Kirklees Council  
Planning and Development Service  
PO Box 1720  
Huddersfield  
HD1 9EL

Date: 09-Sep-2025  
Our Ref: 2025/90119

**Discharge of details reserved by conditions 3 (Phase 2 Report), 4 (Remediation Strategy), 7 (CEMP), 19 (Window Details), 21 (Roofing Materials), 22 (Walling Materials), 23 (Mortar Specification), 24 (Materials (plot 15)), 29 (Boundary Treatment) on previous permission 2021/93006 for conversion of existing barn to form 8 dwellings, erection of 9 dwellings, demolition of redundant agricultural buildings and associated works (Listed Building within a Conservation Area)  
Yew Tree Farm, The Village, Farnley Tyas, Huddersfield, HD4 6UQ  
Application Number: 2025/90119**

APPENDIX I.

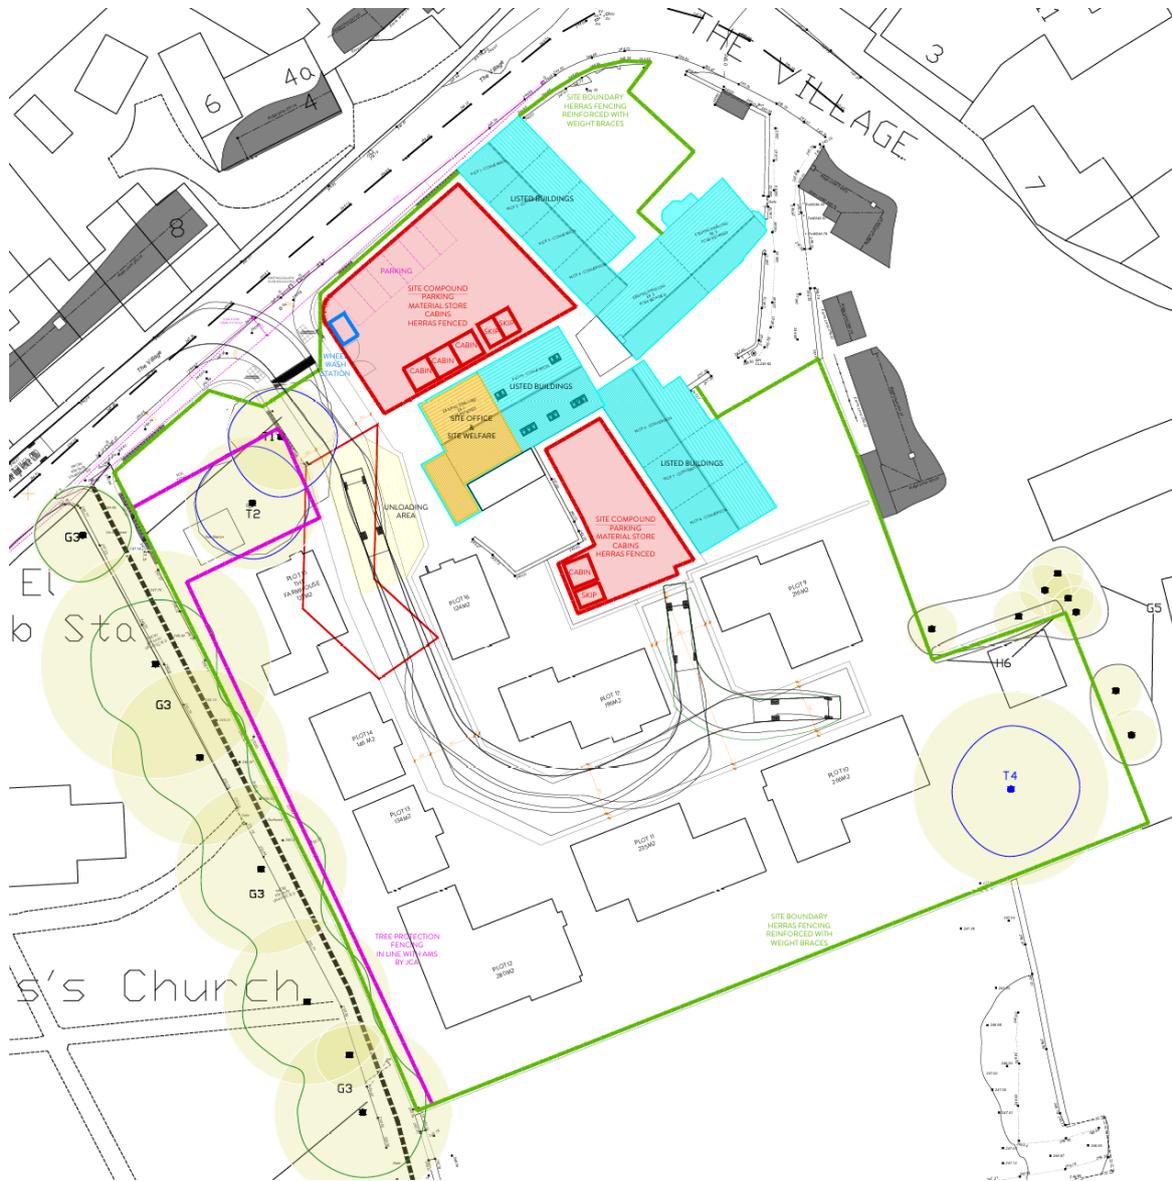
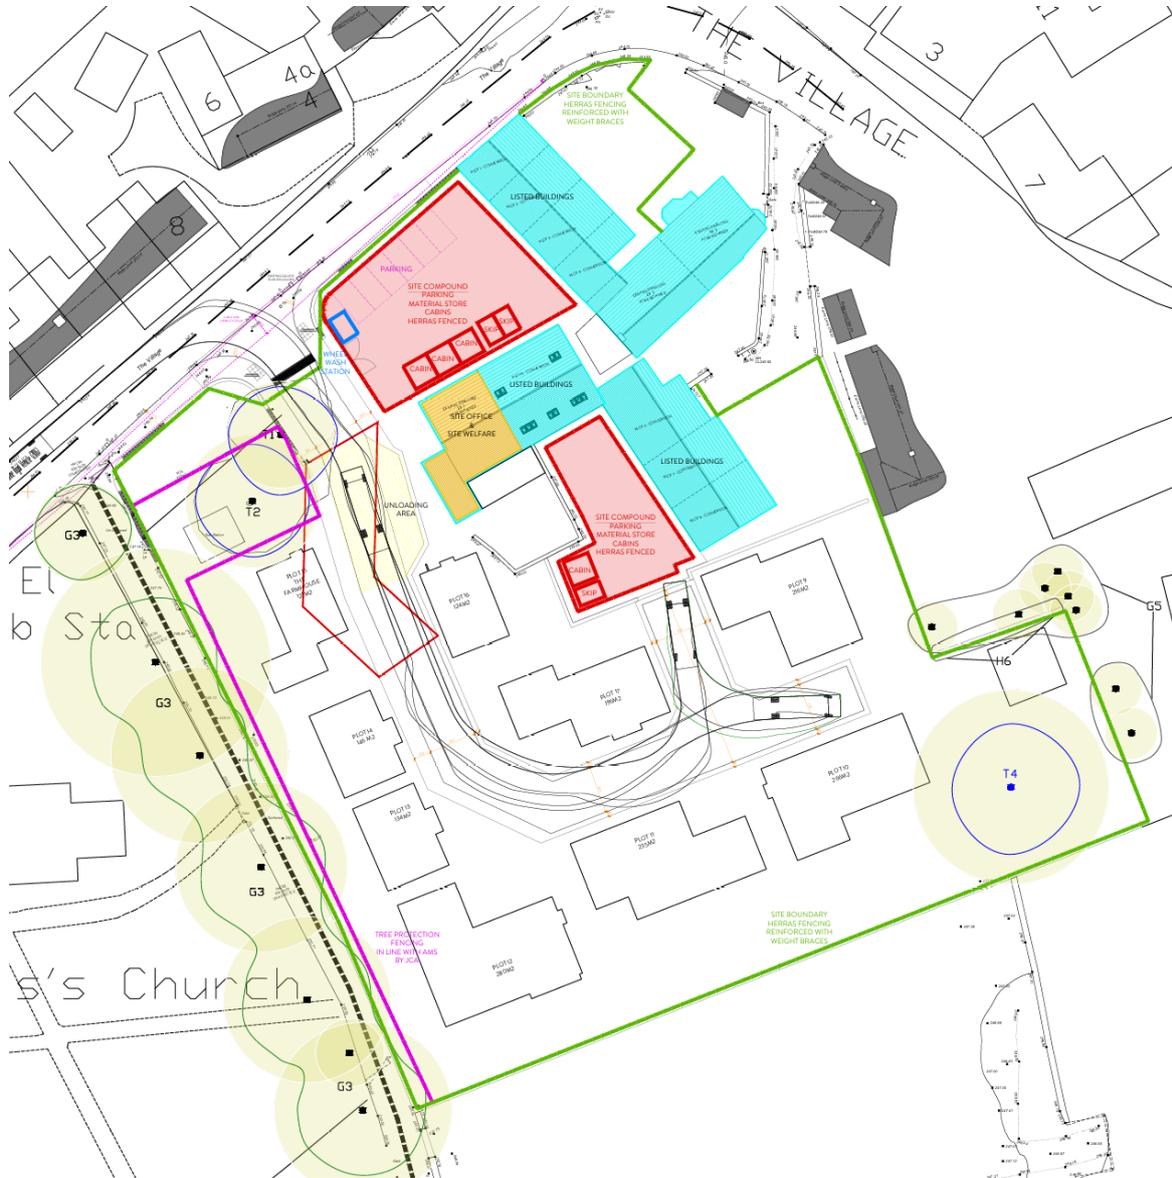
The submitted details are deemed to be acceptable for the initial requirements of Condition 7 and are hereby approved. However, of note, Officers highlight that condition 17 of application 2021/93006 formally restricts the use of the agricultural access road to the south of the site onto Farnley Road, and therefore this road is **not** permitted to be used as an access into the site.

Drg No.	1430/060	Rev	1
---------	----------	-----	---

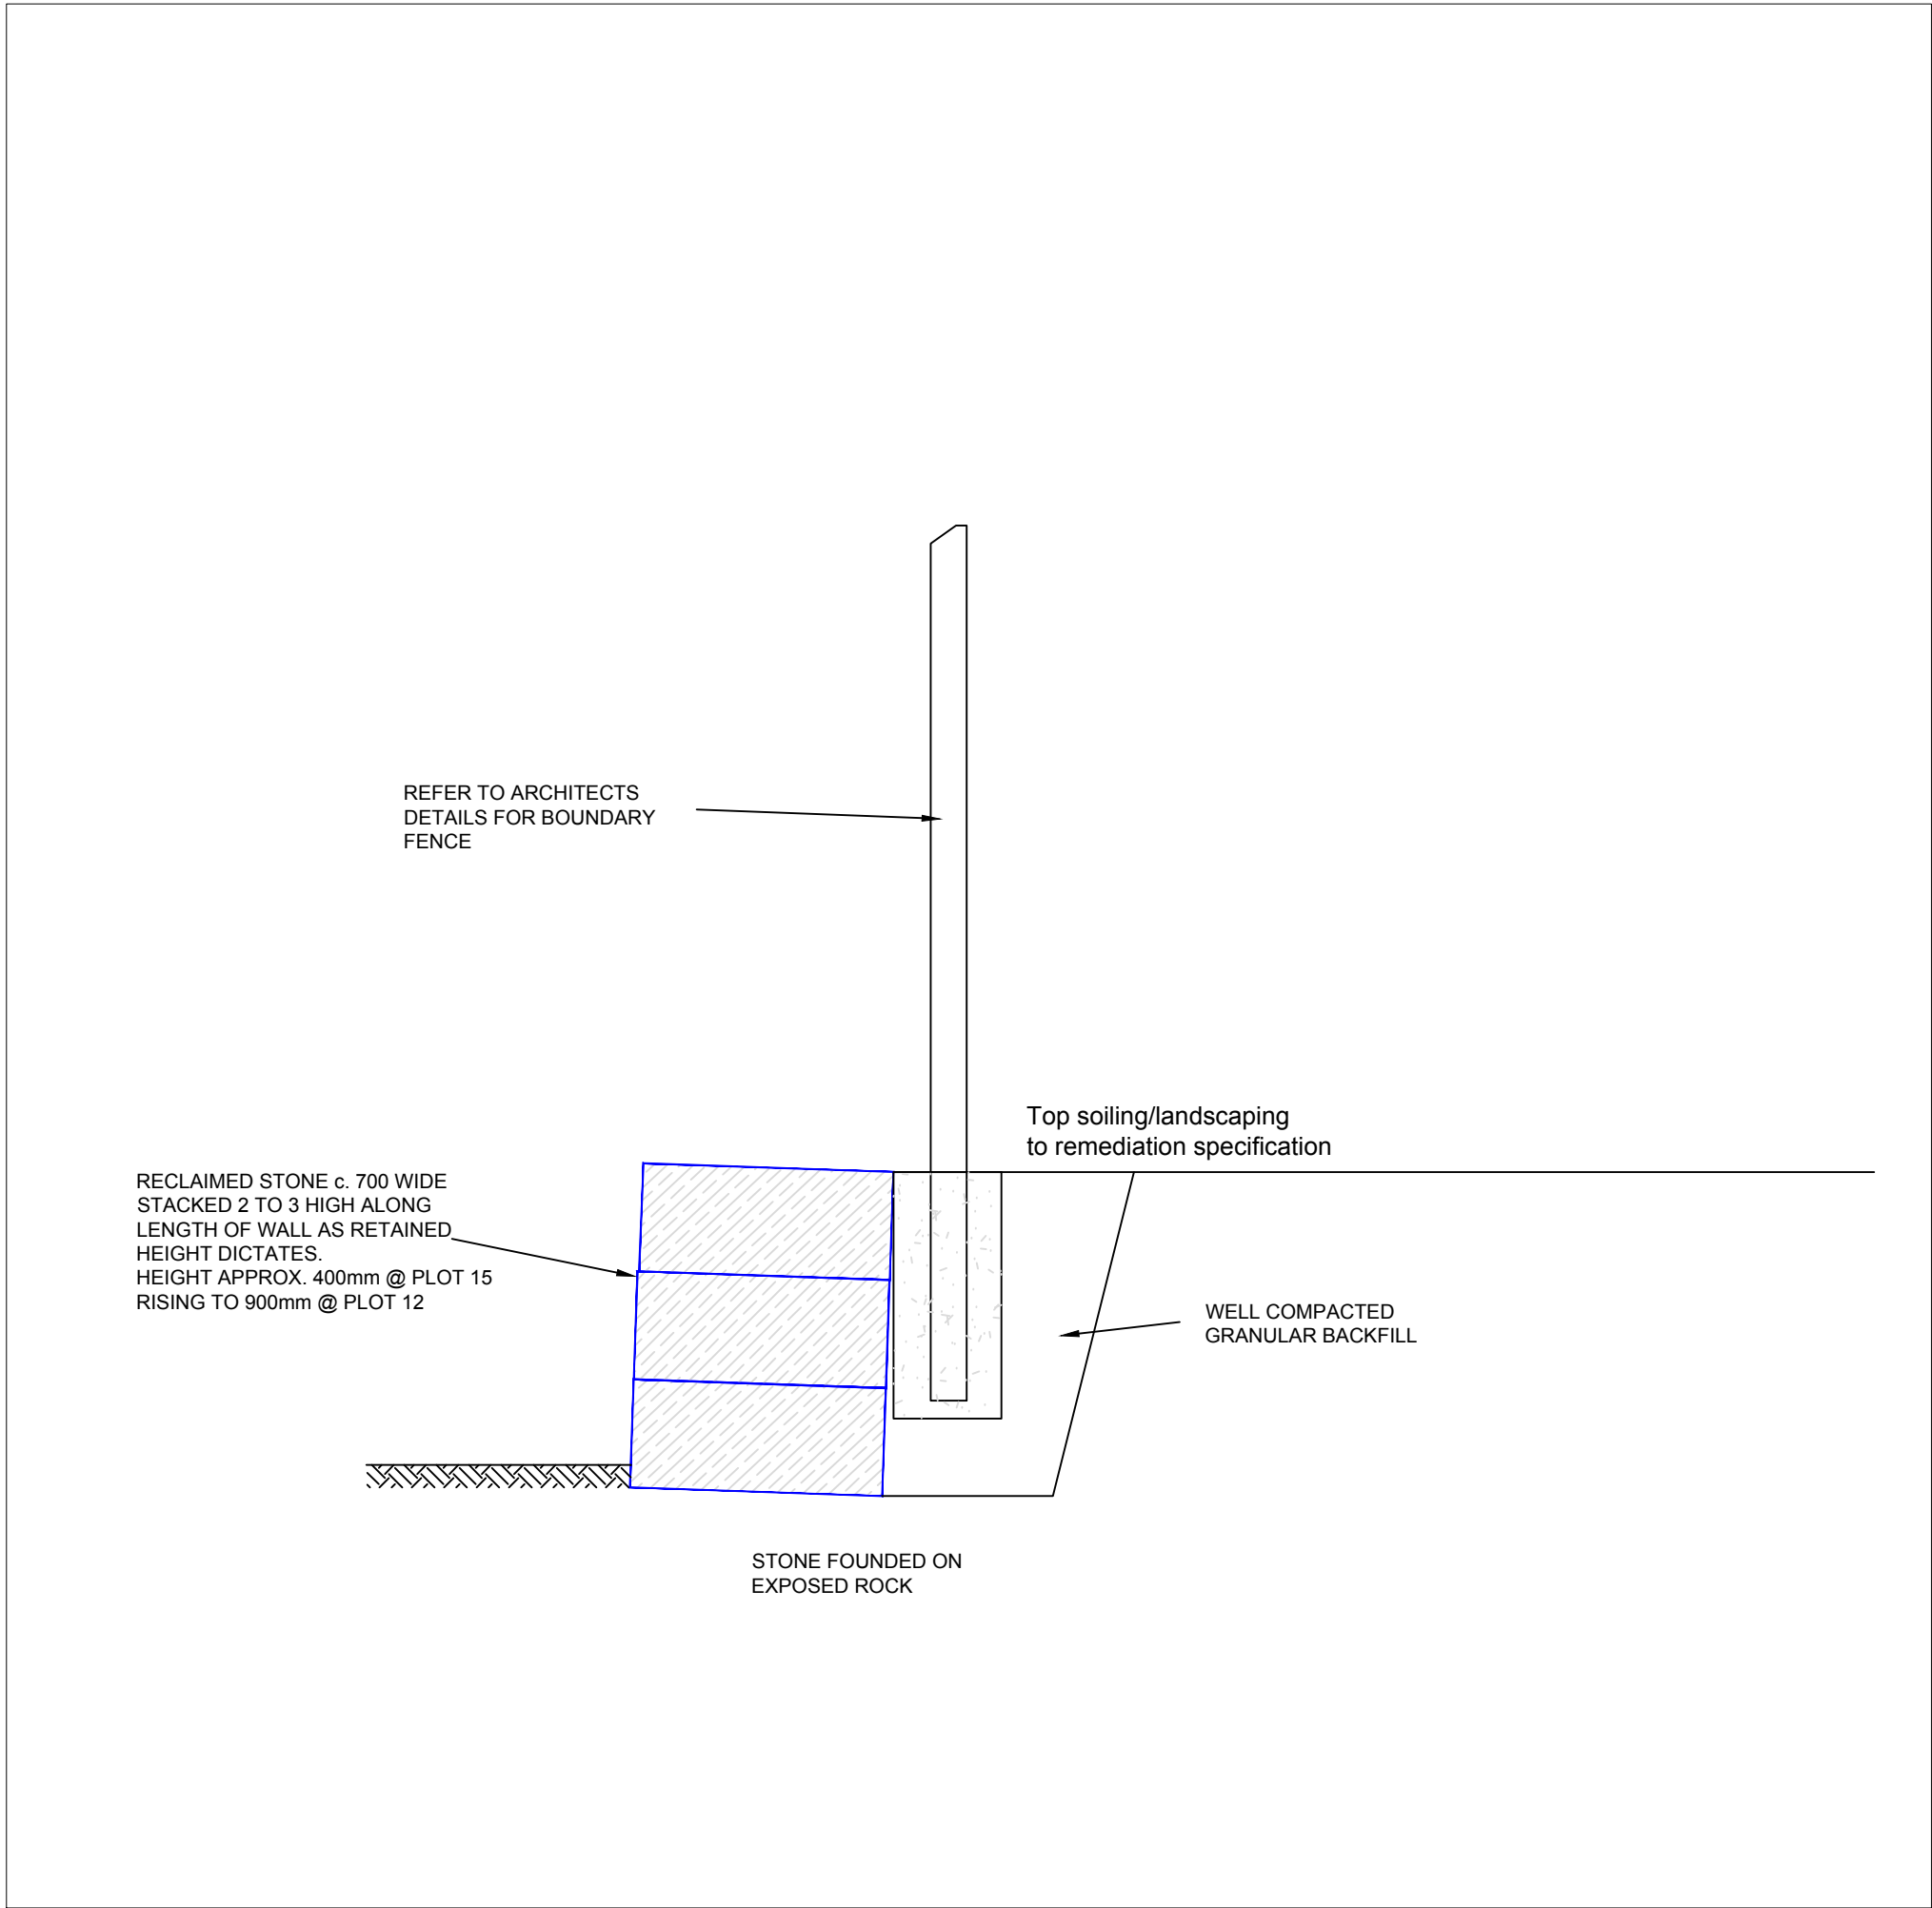
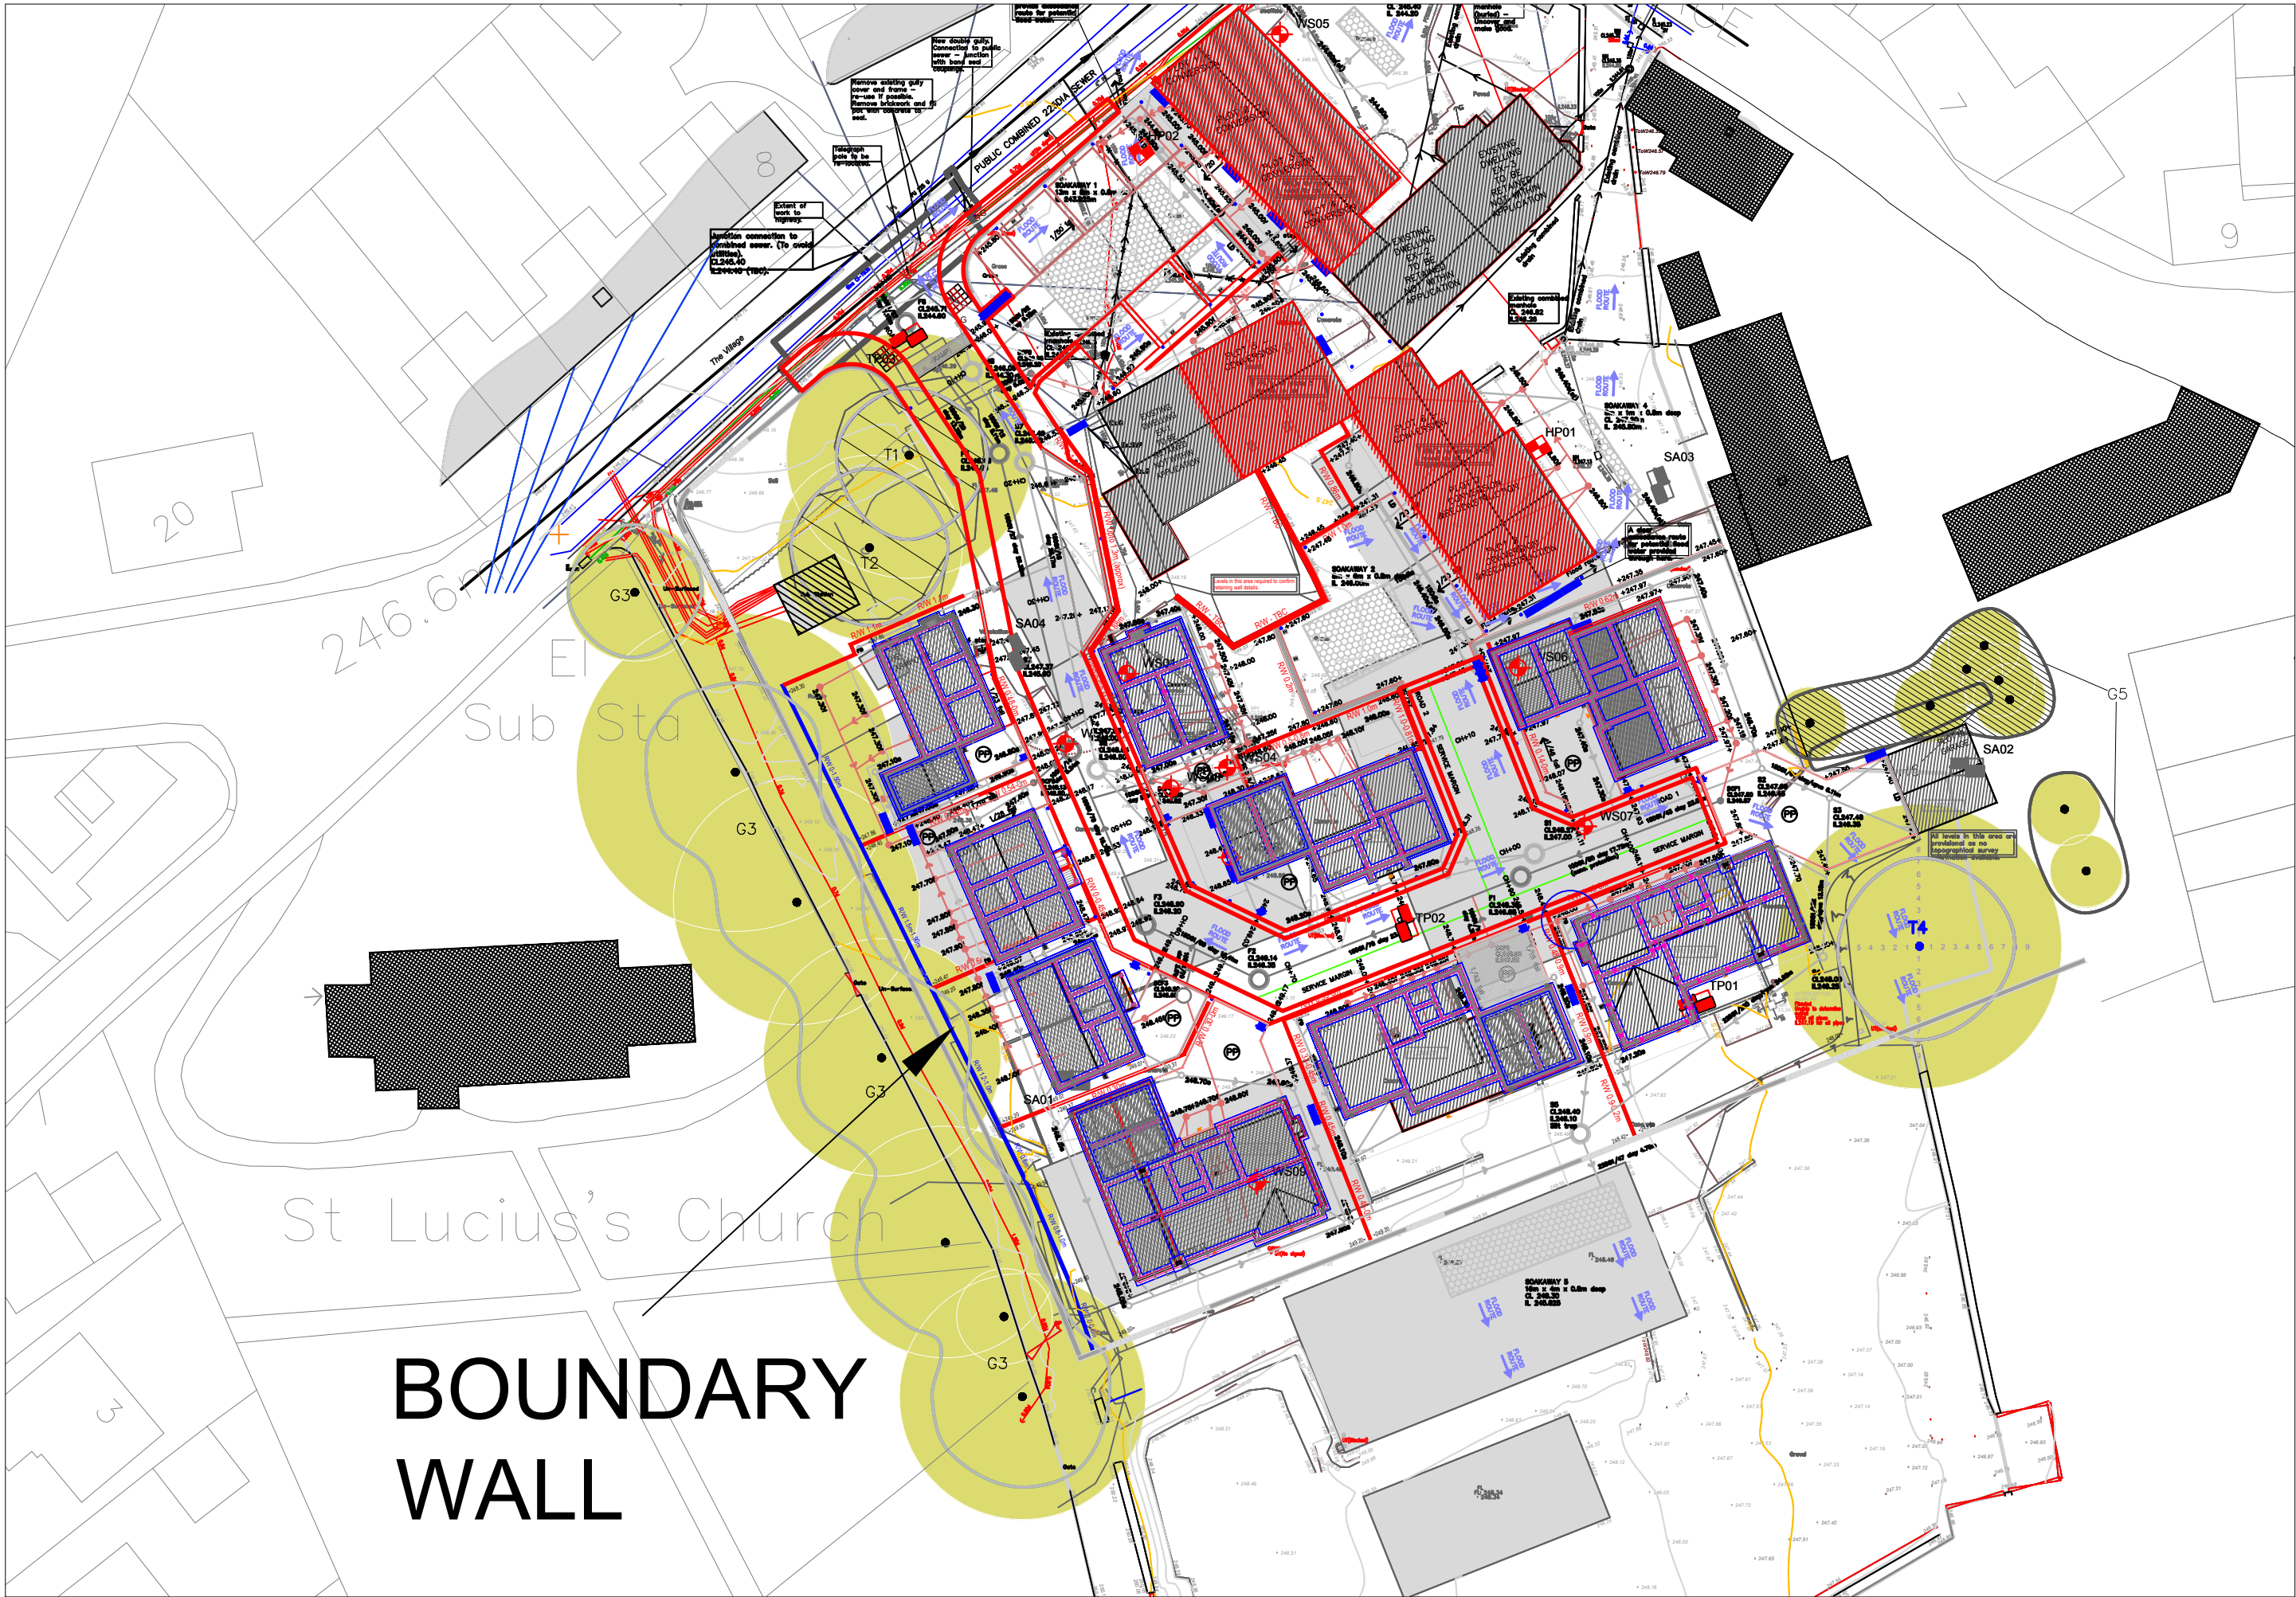
The submitted information does not meet all the requirements of Condition 29, and therefore Condition 29 cannot be discharged at this time.
